Application # 0750017559B

COUNTY OF HARNETT LAND USE APPLICATION

SURVEY FOR:
PINE GROVE DEVELOPMENT CORP.
LOT #52
NATURES CROSSROADS, PHASE TWO
102 ACRES

**Re: Status of Improvement Permit Application #07-5-17559
Nature's Crossroads Lt 52**

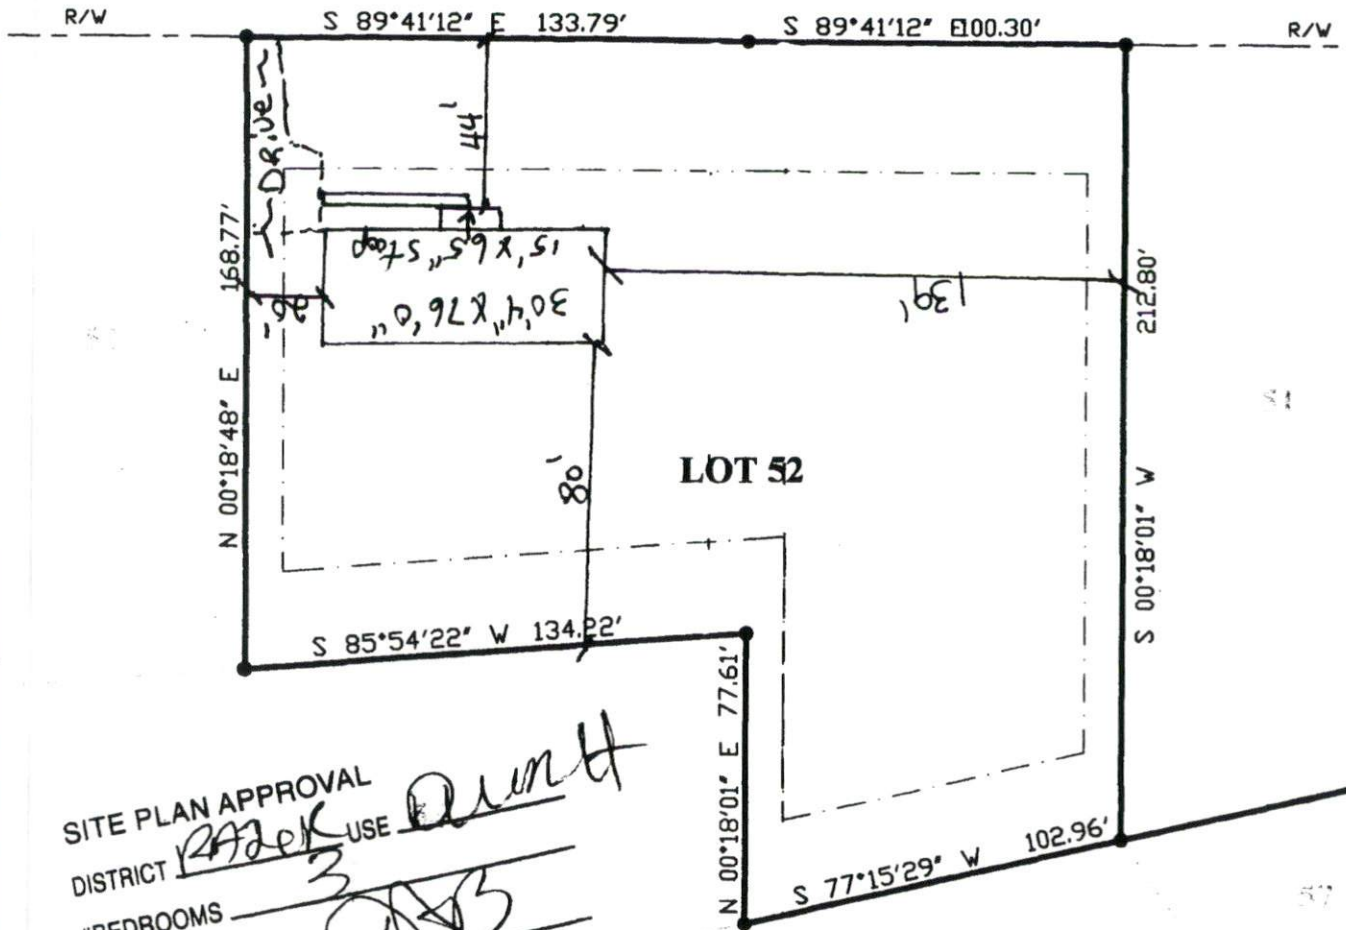
- 1. Property lines/corners not marked or labeled
- 2. House corners not marked or labeled
- 3. Directions not clear to property
- 4. Property needs brush or vegetation removed
- 5. Backhoe pits required
- 6. Other – Move house as shown (see attached sheet) Submit new plot plan to Central Permitting and reconfirm.
